Charlotte-Mecklenburg Planning Department

DATE: September 5, 2013

SUBJECT: Administrative Approval for Petition No. 2008-050 Liberate Financial, LLC

CHARLES AVENUE VILLAGE

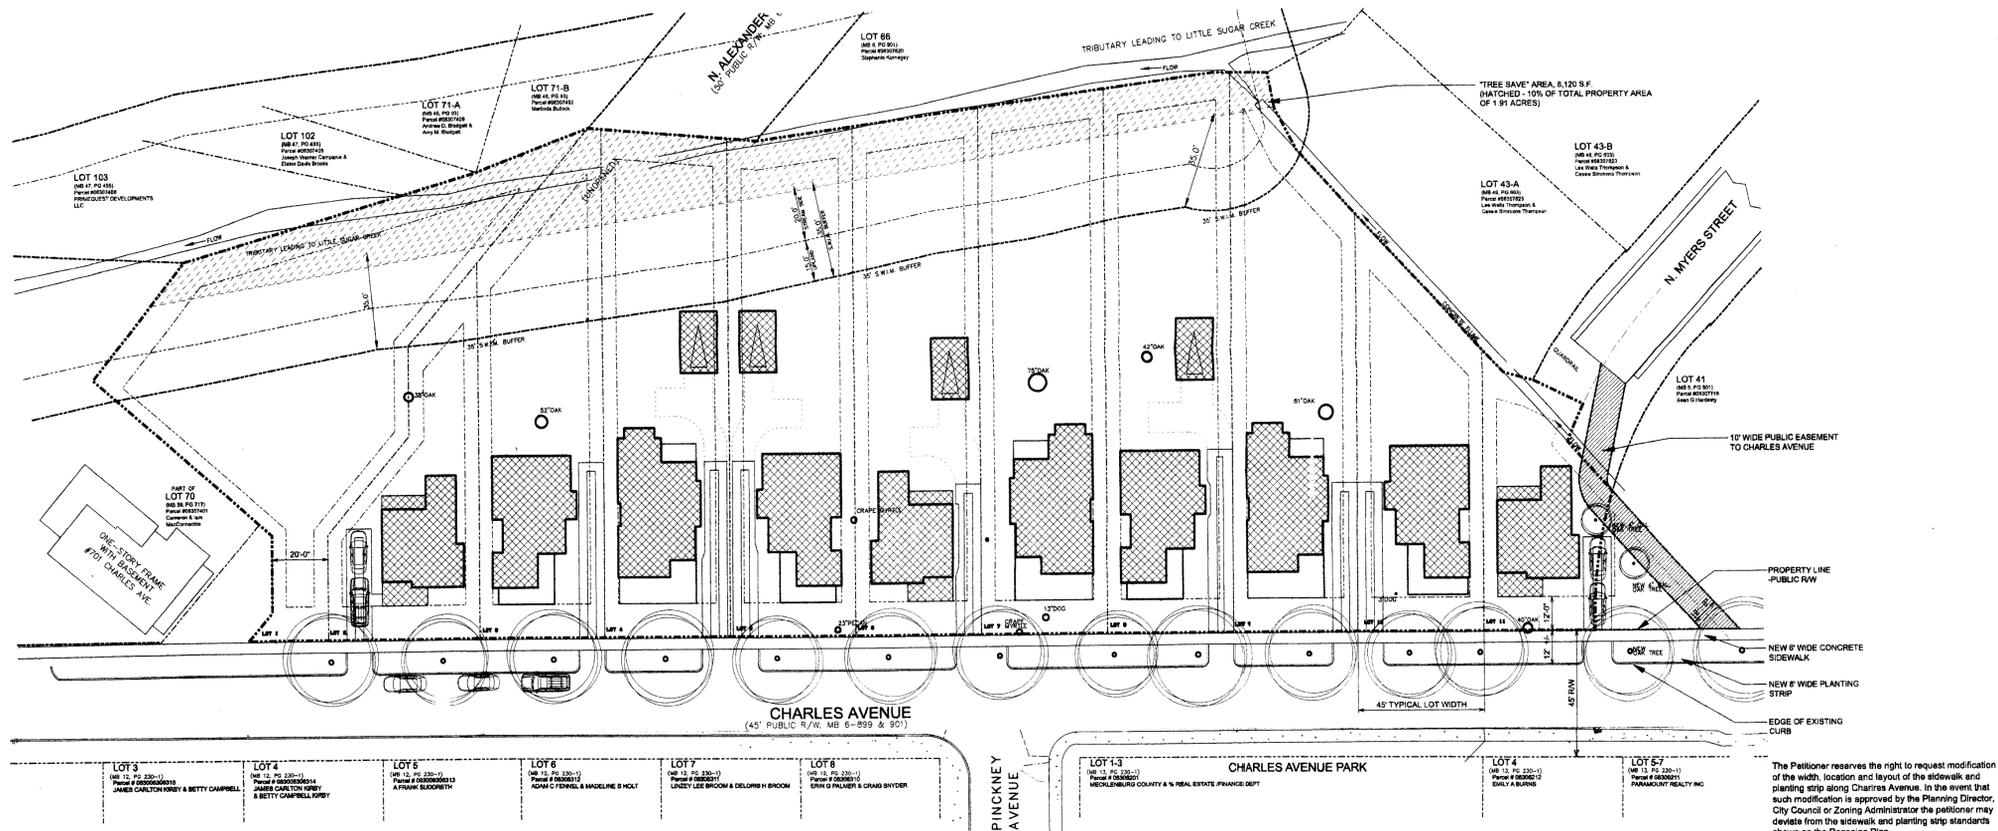
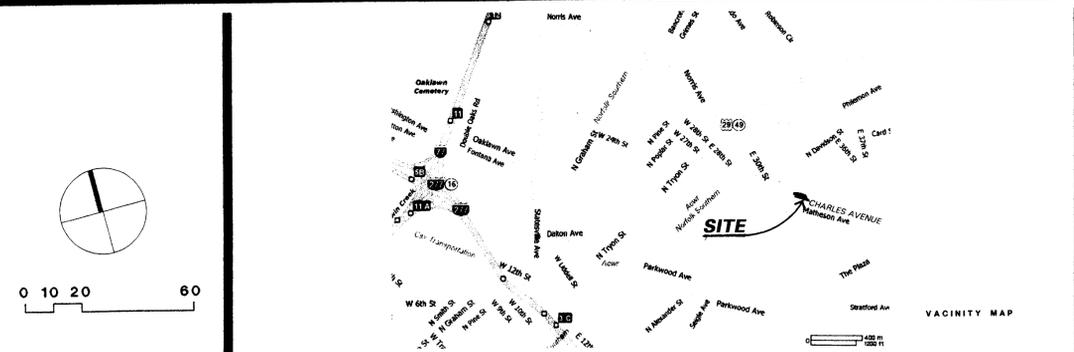
Attached is the revised site plan for the above referenced rezoning petition. This plan allows the modification of the required sidewalk and planting strip per the UR standards in the Zoning Ordinance. Since this change does not alter the intent of the development and meets the requirements of the Charlotte Zoning Ordinance Section 6.207 Alterations to Approval, minor changes, I am administratively approving this plan. Please use these plans when evaluating requests for building permits and certificates of occupancy.
